Our Ref: AW/33/22/NMA

**Section 96A of the Town & Country Planning Act 1990 (as amended)
Town and Country Planning (Development Management Procedure) (England) Order 2015
(as amended) - Article 10**

Non-material amendment following grant of AW/338/19/HH for: the replacement windows & doors have different fenestration, the extent of the new cladding and render to the external walls differs from the original application; First Floor double doors to the rear balcony have been replaced with Juliet balcony doors; balustrade to the front balcony has changed; the chimneys have been removed; new opaque screening has been added and the new rear privacy wall has been raised higher.

9 Meadow Way Aldwick PO21 4HG

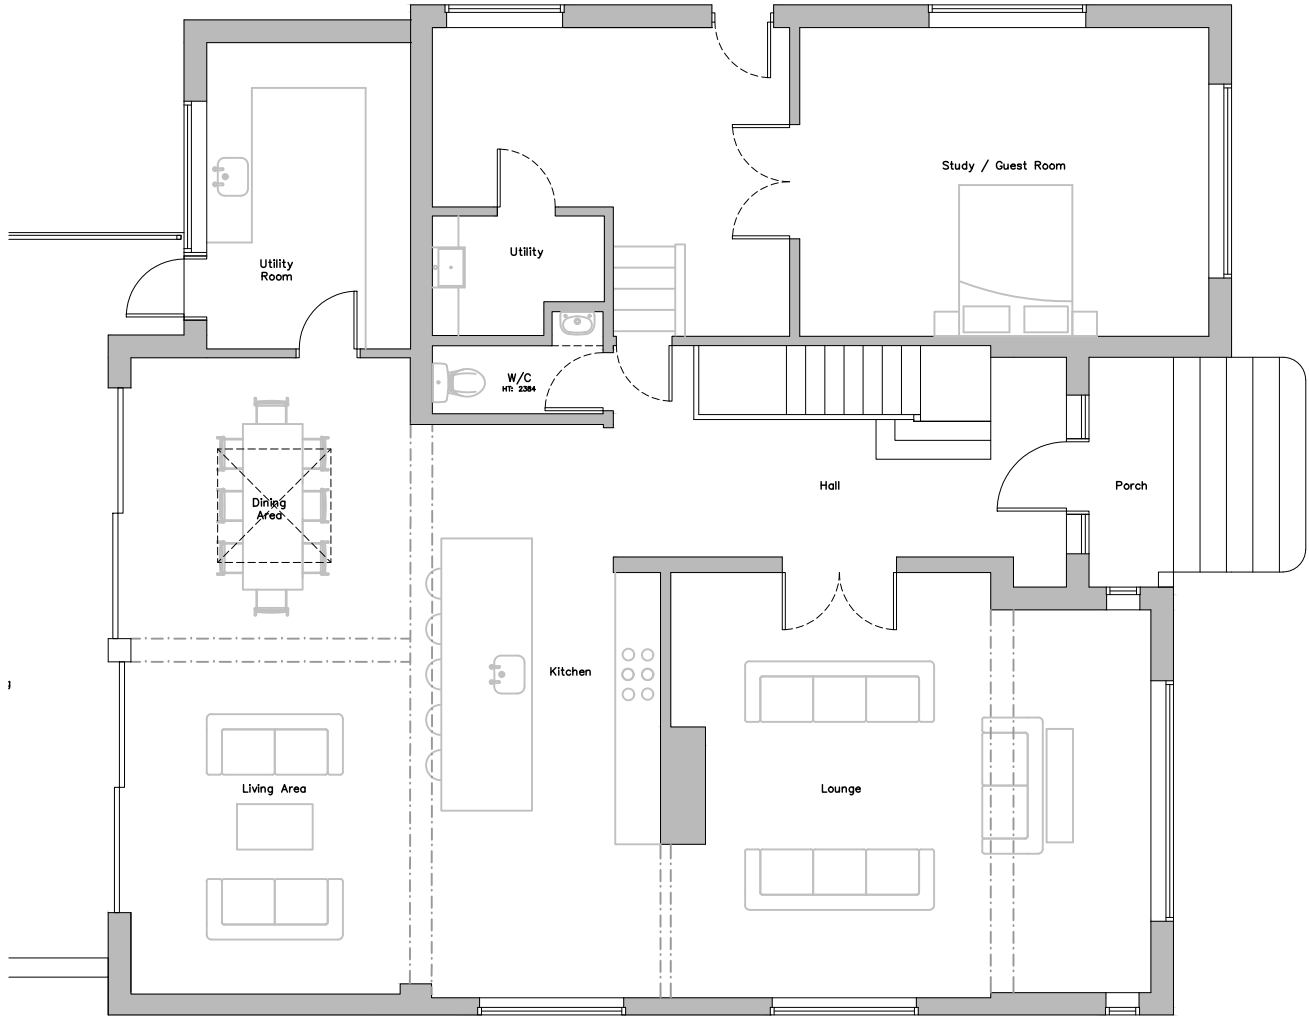
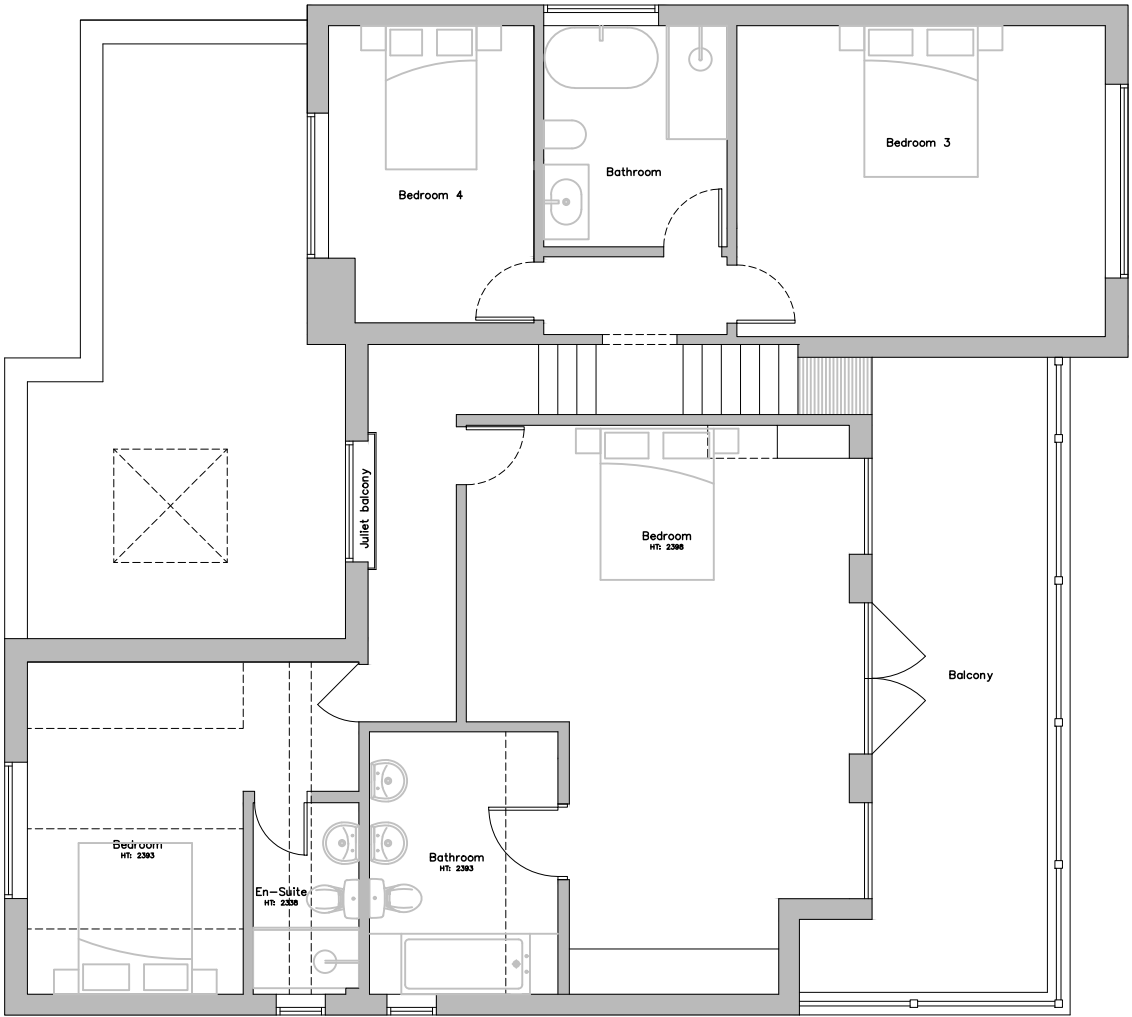
- Alterations to the design of the windows and doors.
- The extent of cladding and render has altered.

- First floor double doors to the rear balcony have been replaced with juliet balcony doors.
- Front balcony balustrade has altered in design.
- Removal of the chimneys.
- Alterations to the screening to the rear which has increased in height.

A condition on the original permission included ' Balcony screening to the first floor southern elevation shall be constructed prior to the first use of the balcony, to a height of 1.7m and shall at all times be obscured glazed and be retained thereafter in perpetuity.' This application does not avoid the need to comply with this condition.
